Your ref 3/2012/0396
Our ref PG/LAWS/3/35/8457
Date: 20 July 2012

APPLICATION NO. 3/2012/0396
LAND ADJACENT TO MANOR CROFT, GLEN AVENUE, KNOWLE GREEN,
LANCASHIRE, PR3 2ZQ
GRID REFERENCE 363637 - 437964

A planning application has been submitted by Mr Roger Treacher of Hughes Treacher on behalf of Mr and Mrs McLaughlin for the erection of an agricultural building for alpacas and the storage of hay and agricultural implements and associated hardstanding. An inspection was made on 3 July 2012 whilst the applicants and their agent were present. The information provided at this meeting, together with the written submissions, forms the basis of this appraisal.

Dwg No. 1213/04

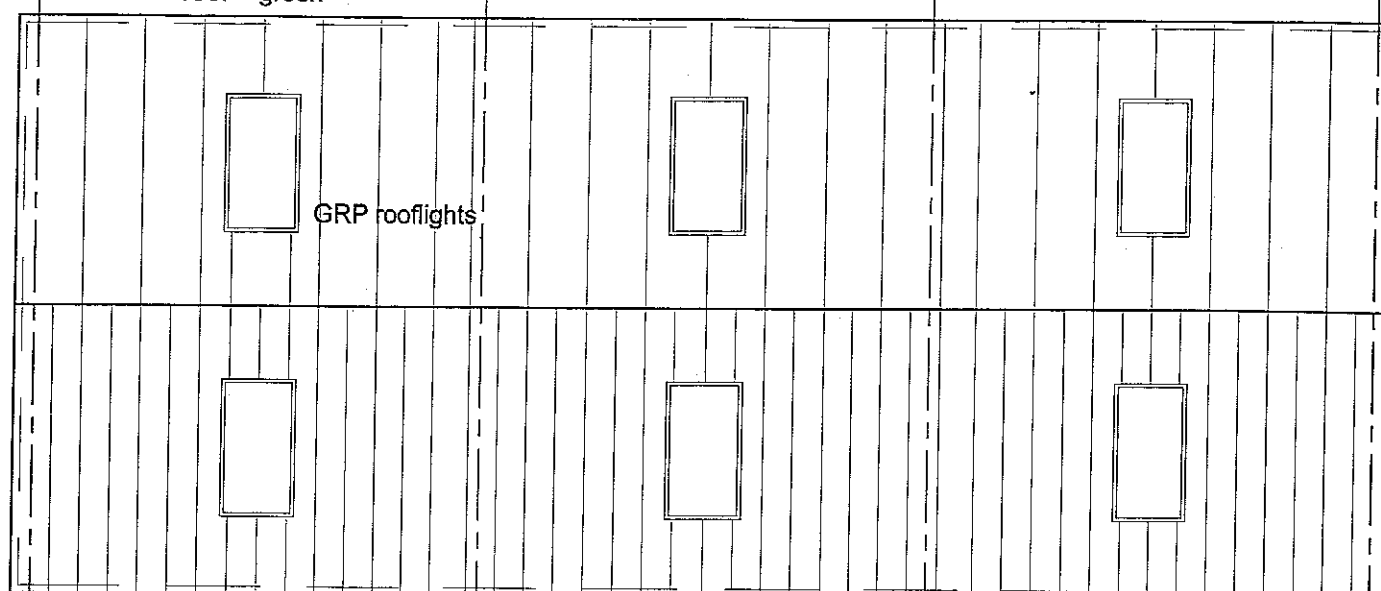
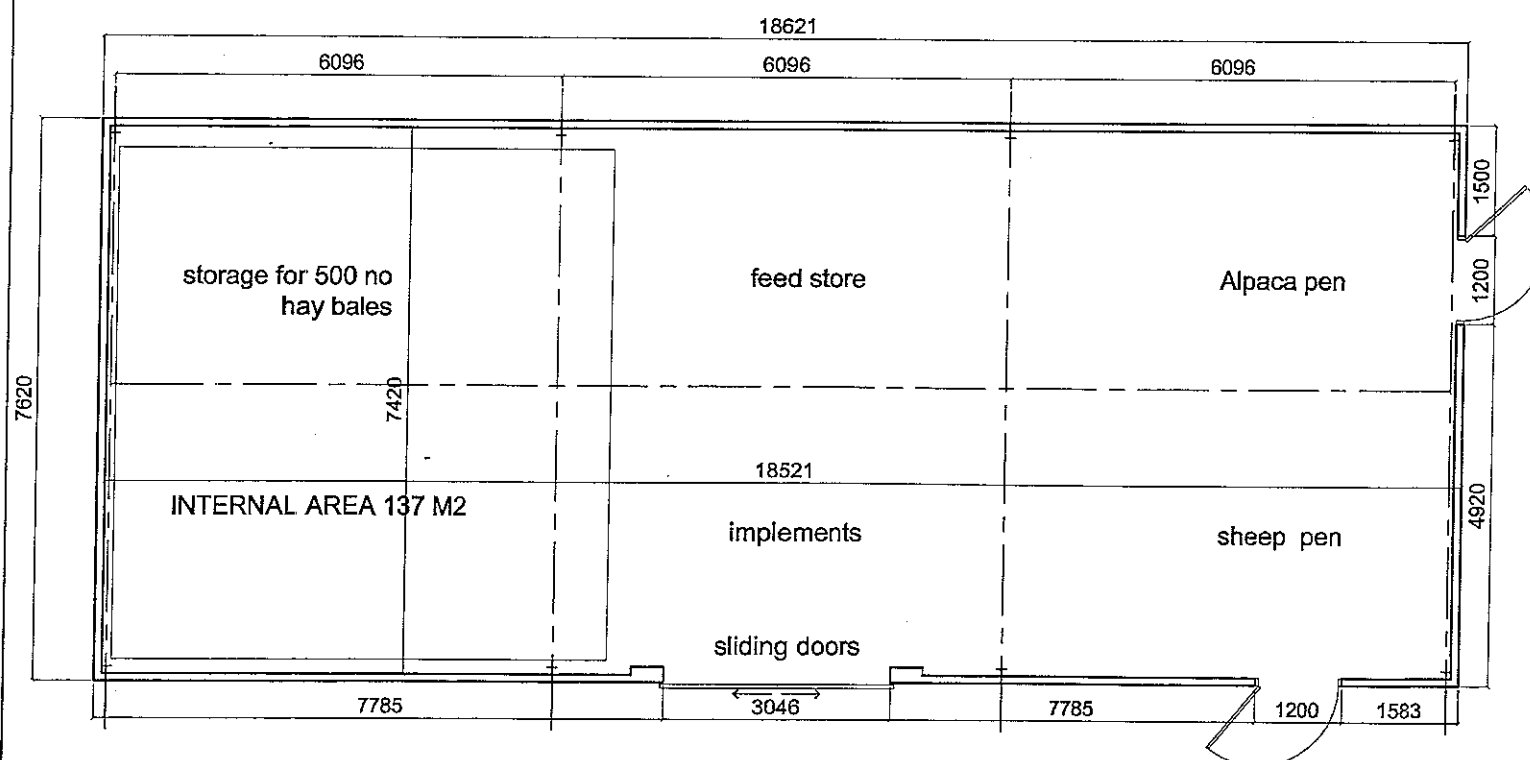
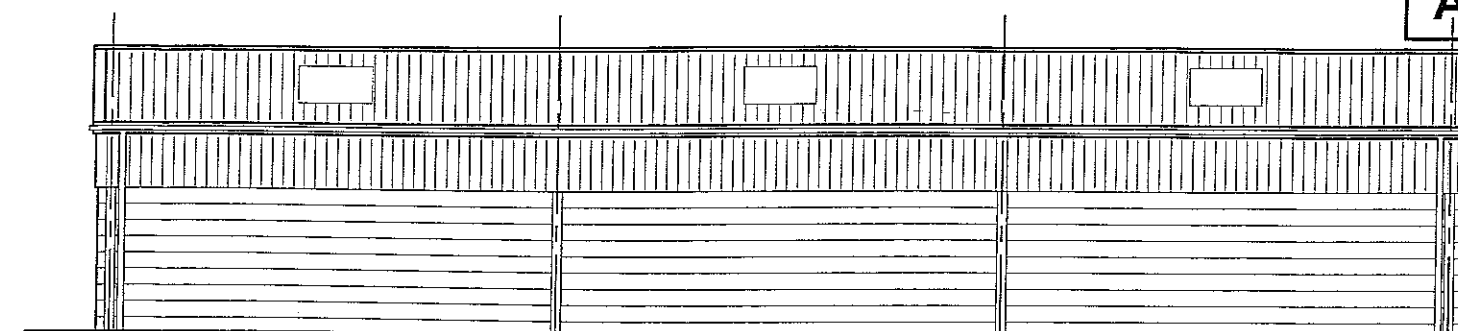
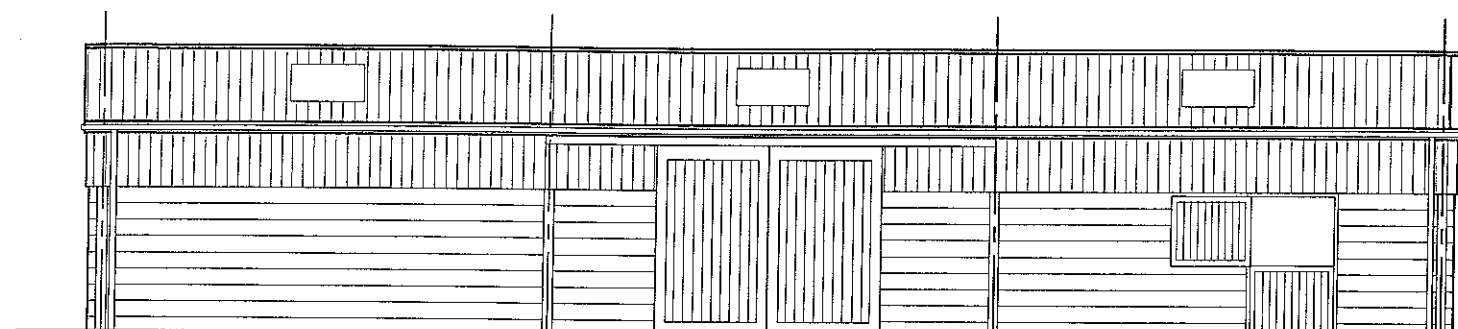
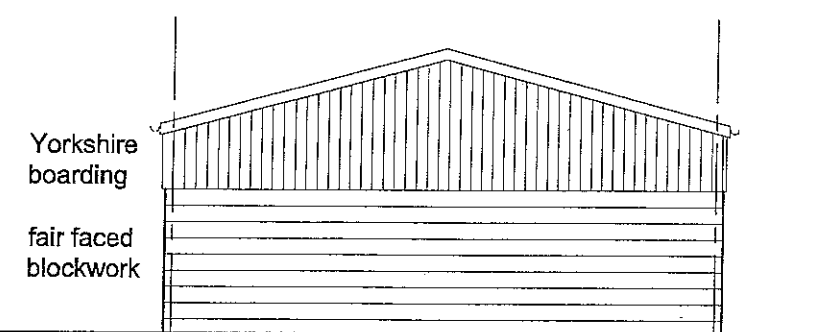
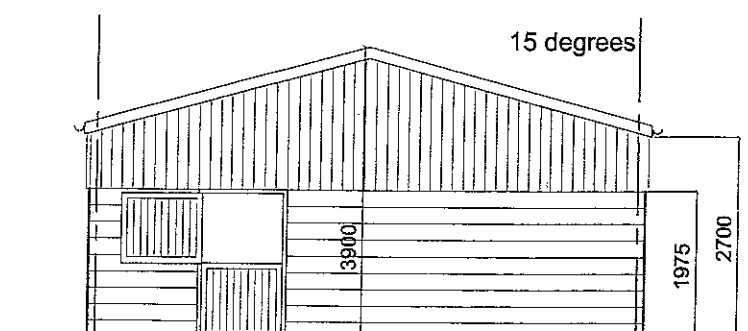
It is proposed to erect a three bay building measuring approximately 18.62m x 7.62m with an eaves height of 2.7m. Details of the proposed building are shown on drawing number 1213/04. The building would be constructed with block walls with Yorkshire boarding above and a fibre cement roof.

Whilst I consider a facility is required, in my opinion, taking into account the scale and type of activities carried out, I am of the view that the size of the building is larger than necessary, with a building in the region of 100 square metres being

adequate. This could be achieved by removing a bay or keeping three bays and reducing them to 4.5m bays.

In addition to the proposed floor area, I also do not consider a brick built building to be essential, with timber walling being suitable for the intended use. I would also comment that the doorways to the livestock area appear to be narrow (1.2m) and in my opinion a wider opening more akin to the sliding doors would be beneficial, particularly if the area is to be used as a shelter allowing animals to come and go.
